MMC traffic information & trip distribution - need for meeting Thursday?

Hi Nell – I have reviewed the trip assignment methodology contained in the April 18, 2018 email from Randy Dunton and I have the following comments:

Existing Employee Garage Trip Assignment

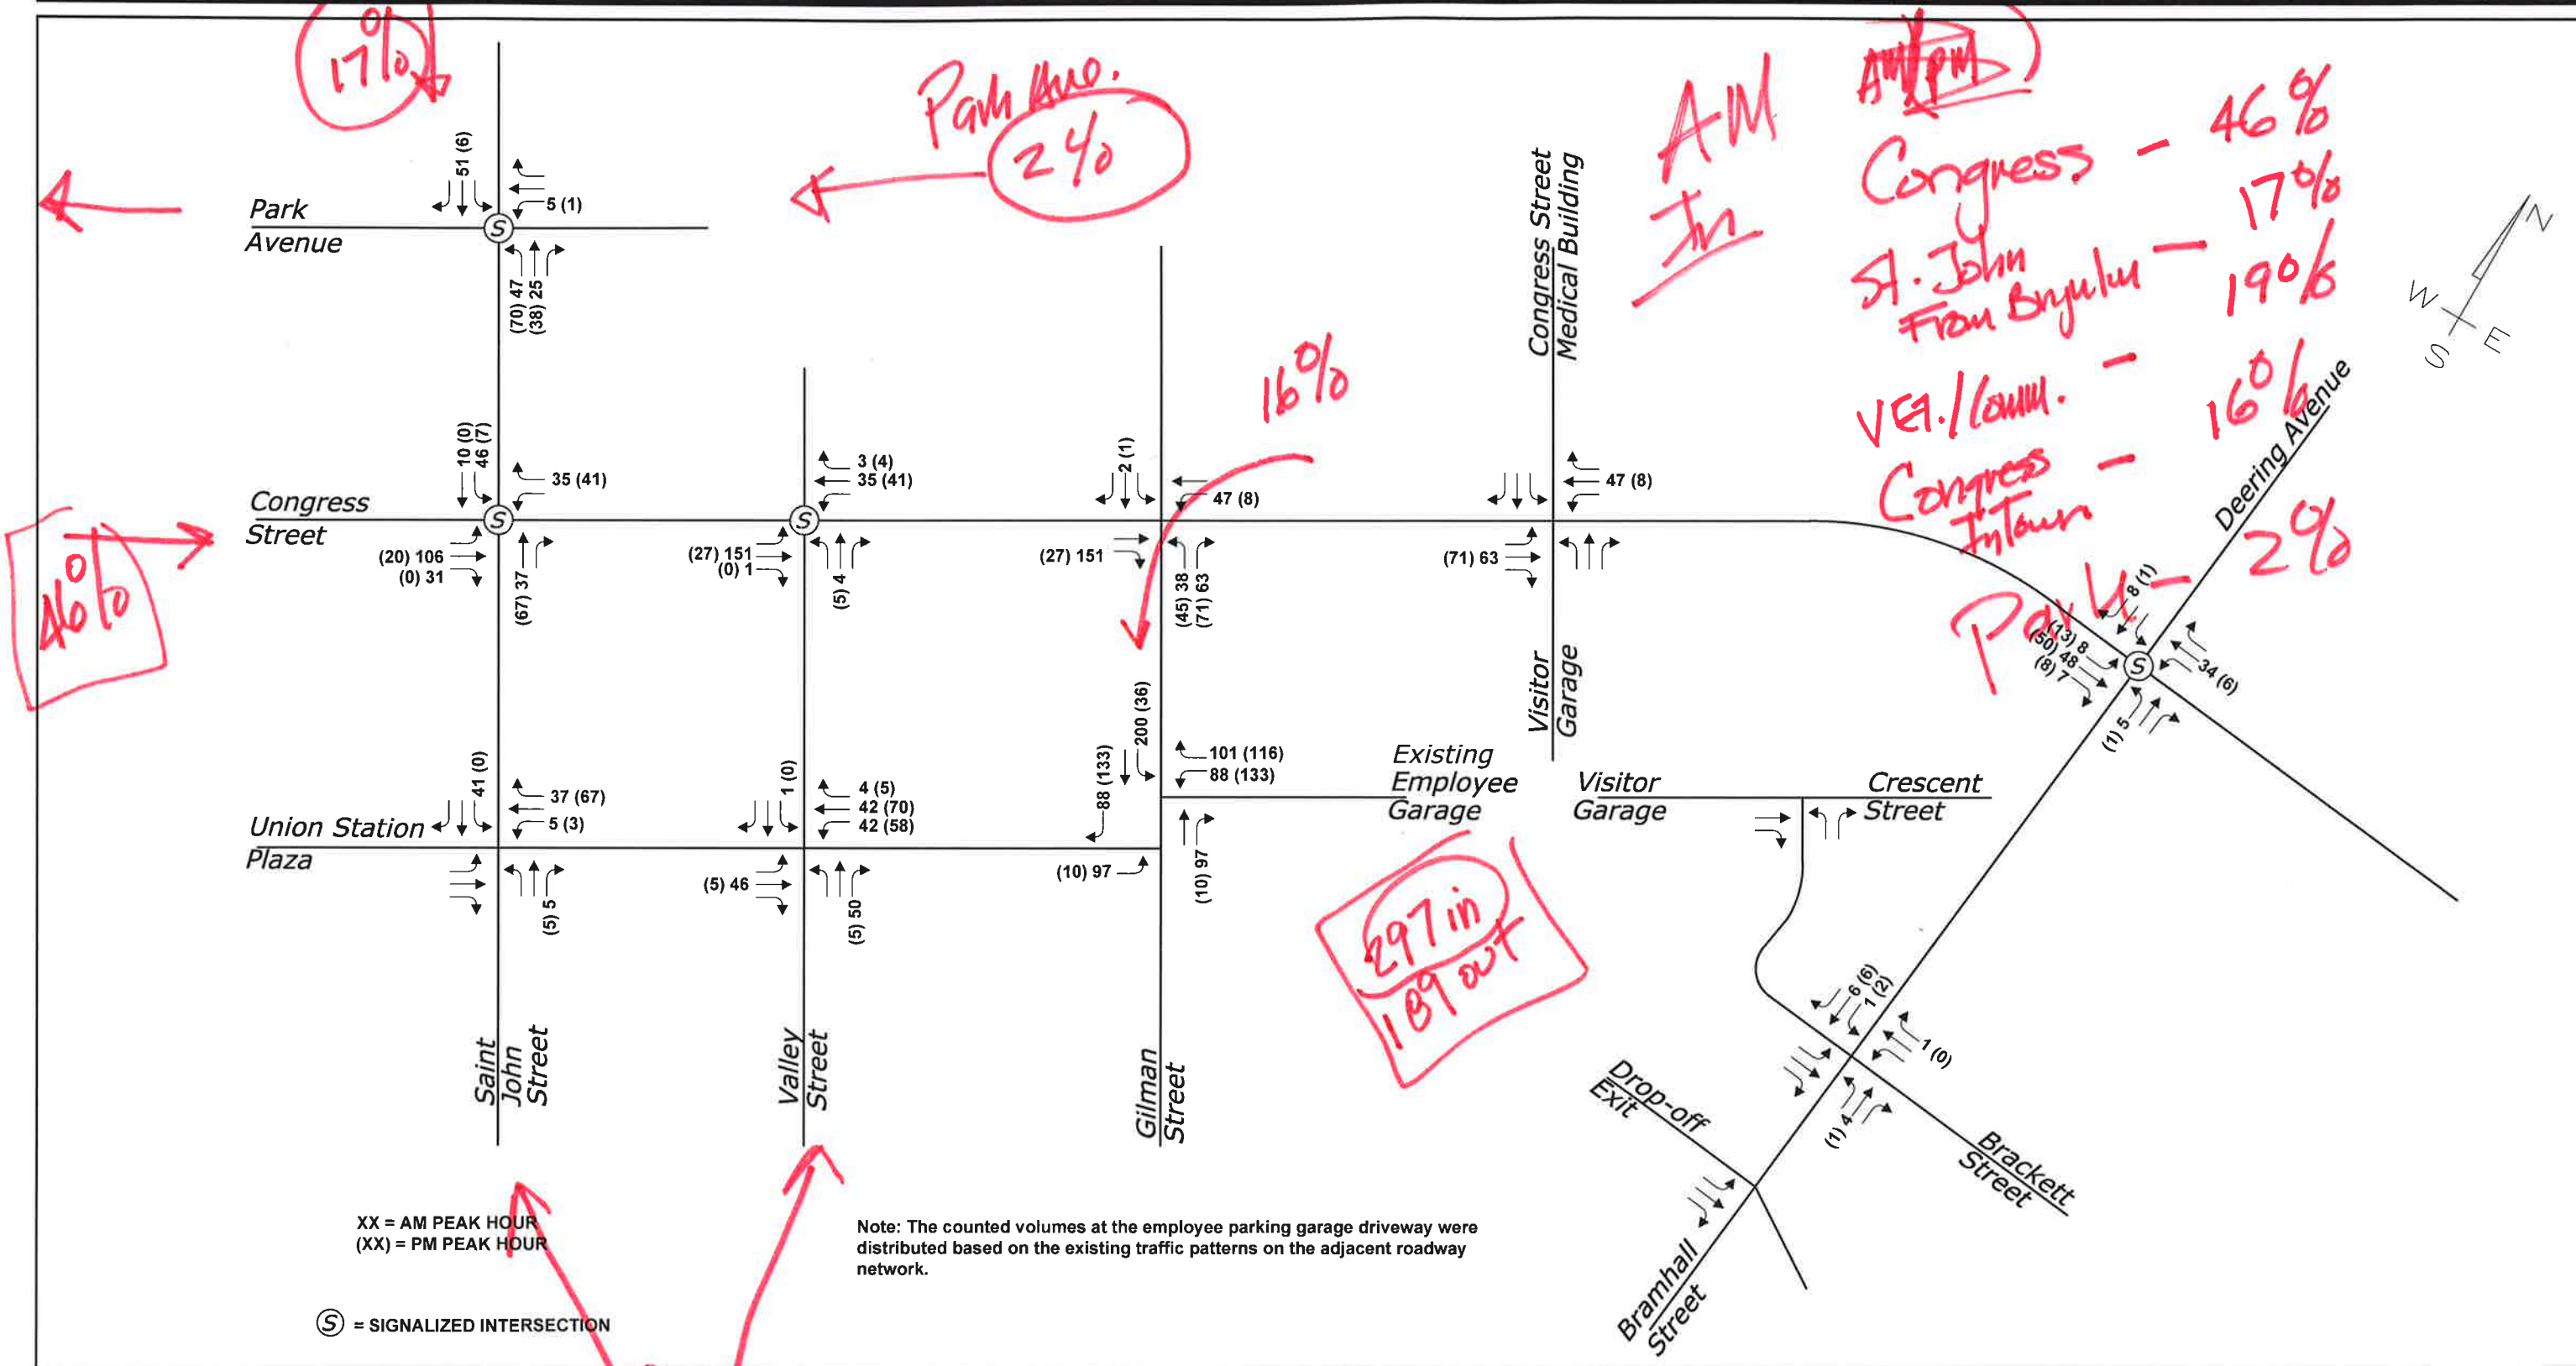
- g. 9% of the trips are assigned to the Peninsula with 2% via Commercial Street and 7% via Congress Street. **[VHB estimated 9%]**
3. GPCEI previously provided an Existing Employee Garage Trip Assignment estimate for the AM and Peak hours. This was based upon a traffic count at the existing garage and turning movement volumes at nearby intersections. The approximate outcome is noted below:

- a. During the AM peak hour the following inbound assignment was estimated:
 - Congress Street from west – 46%
 - St. John Street/Valley Street (VMB and outbound Commercial) – 19%

- Park Avenue WB to St. John Street – 2%
 - Congress Street from east to Gilman Street – 16%
 - Brighton Avenue via St. John Street – 17%

b. During the PM peak hour the following outbound assignment was estimated:

- Park Avenue to the west – 28%
- St. John Street/Valley Street (VMB and inbound Commercial) – 25%
- Gilman to Park Avenue EB – 29%
- St. John Street to Brighton Avenue – 15%

Based upon the above, I would suggest that the two sets of information be merged in the development of a final assignment. In general, the VHB regional travelshed methodology seems reasonable. What is not clear is how motorist will route to the travelshed areas, particularly in the vicinity of MMC. Some notable discrepancies:

- Congress Street inbound from the west approaching St. John – 23% vs. 46%
- Brighton Avenue – 28% vs. 17% in AM and 15% in PM

VHB Travelshed Analysis

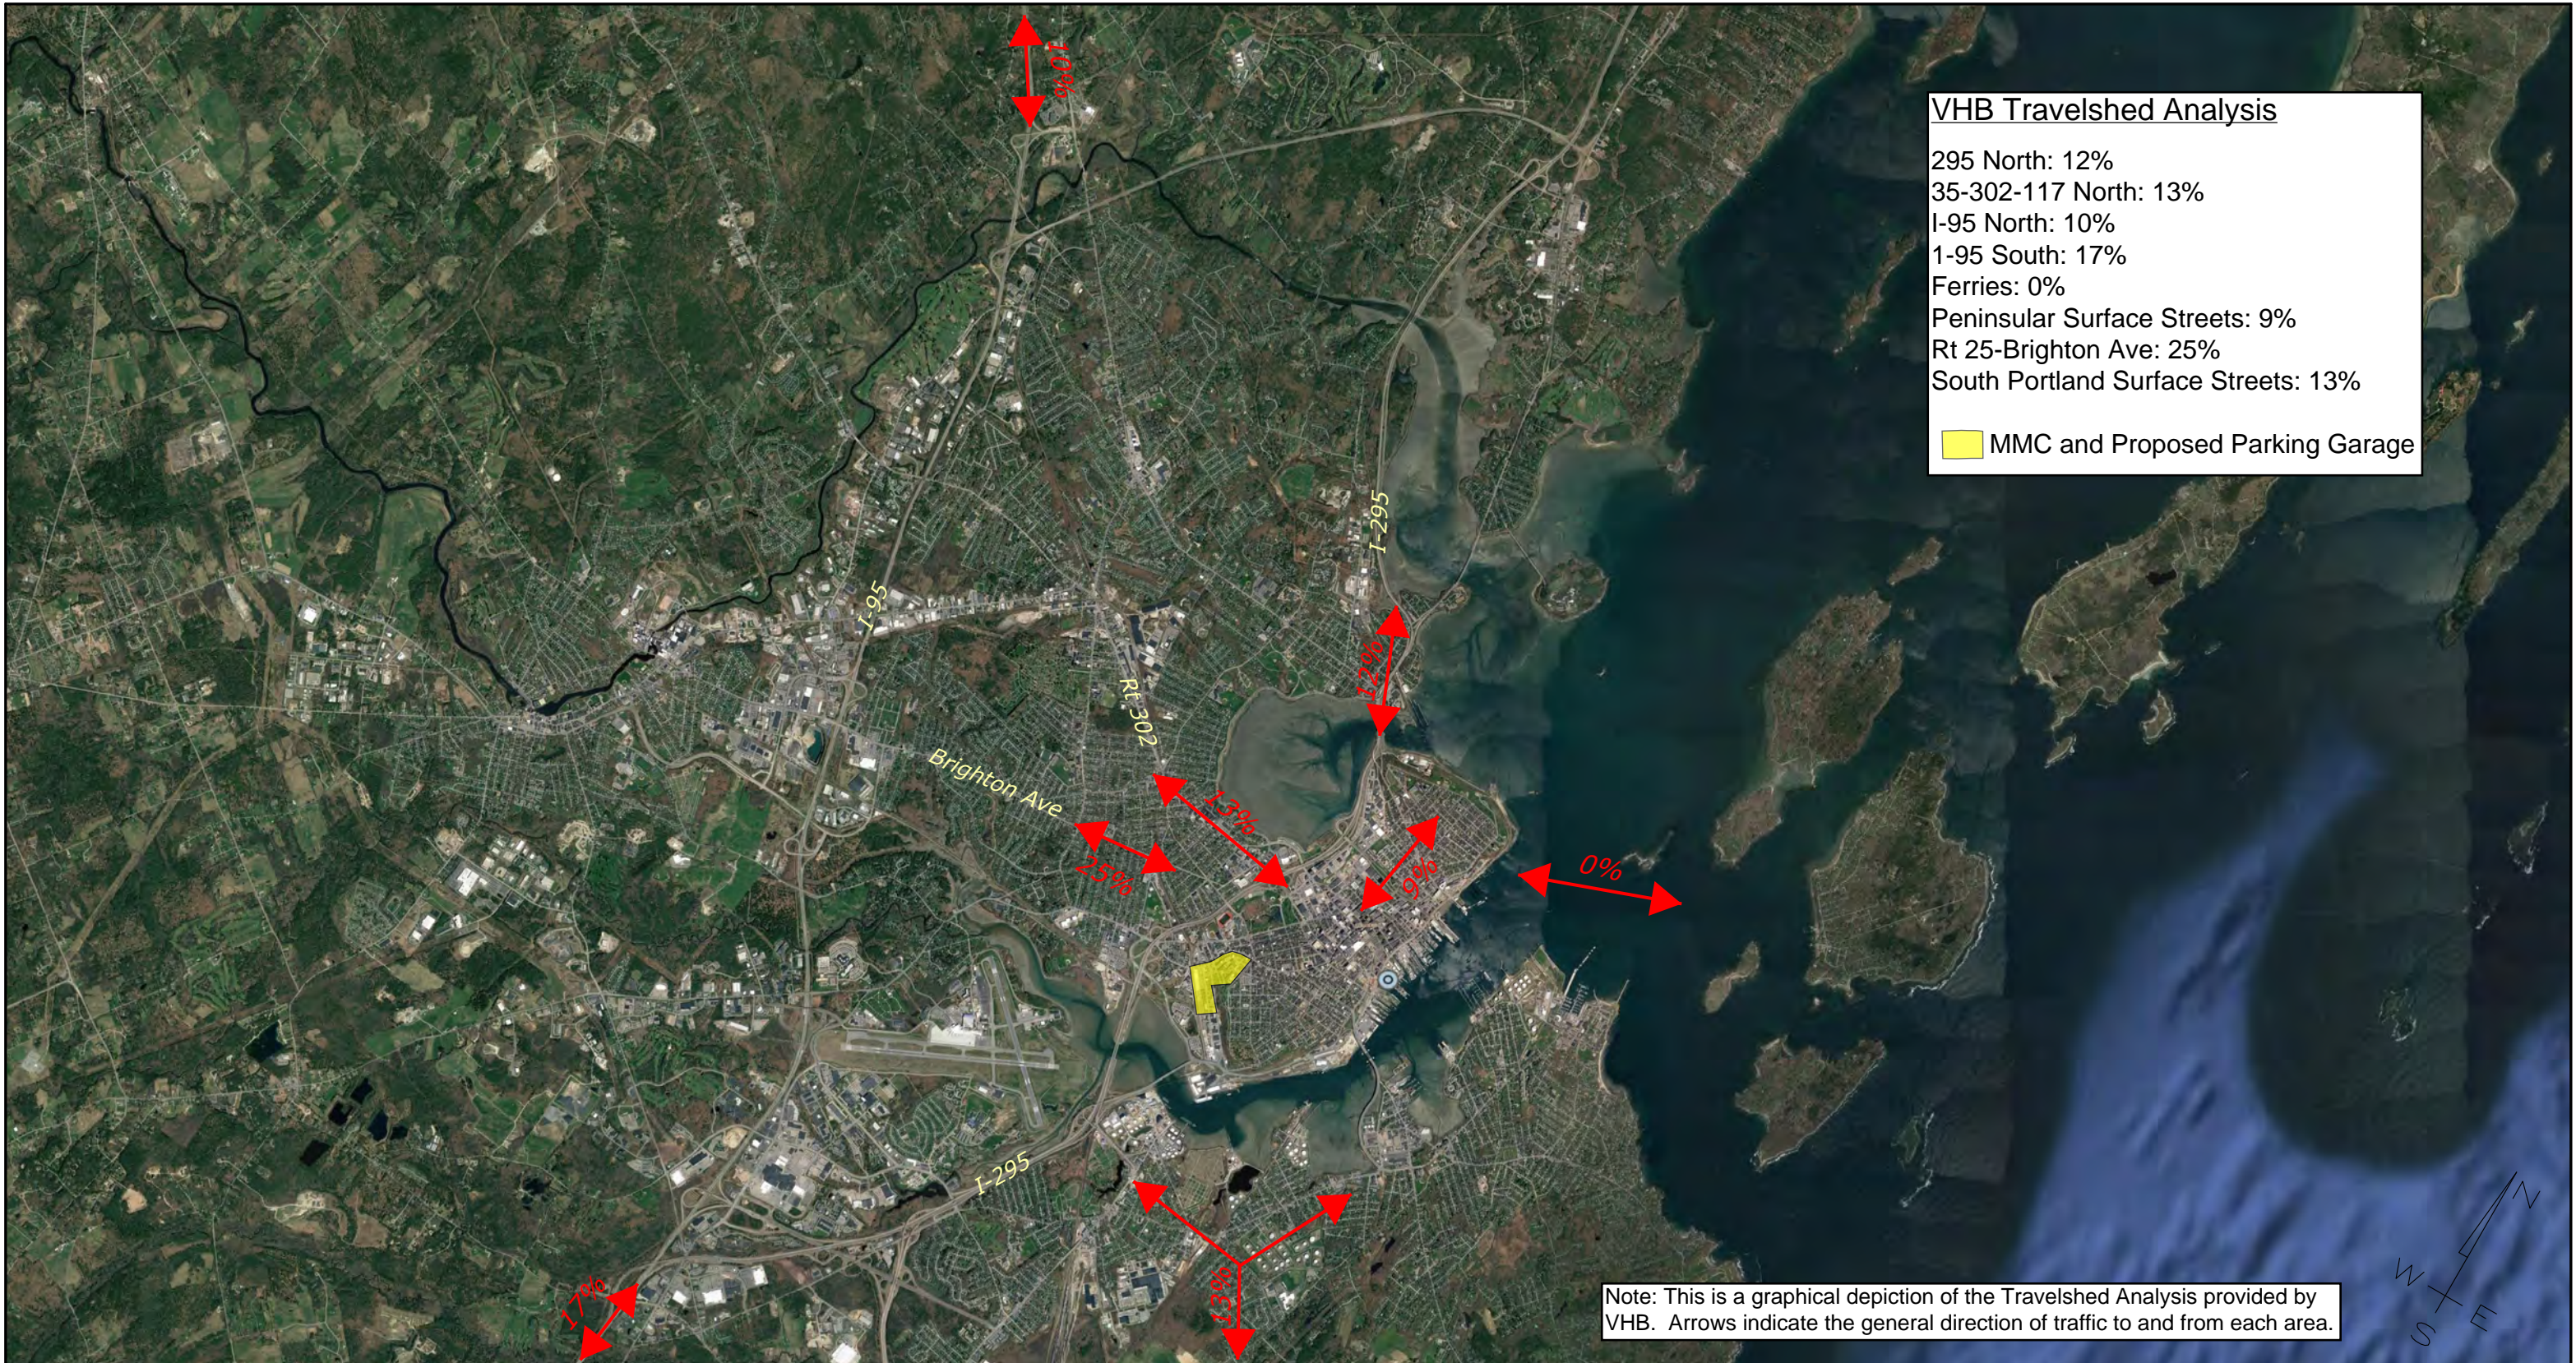
2. The regional assignment of trips closely matches the VHB Employee Travelshed analysis with the following conclusions:
 - a. 17% of the trips are from I-95 (from the south). **[VHB estimated 17%]**
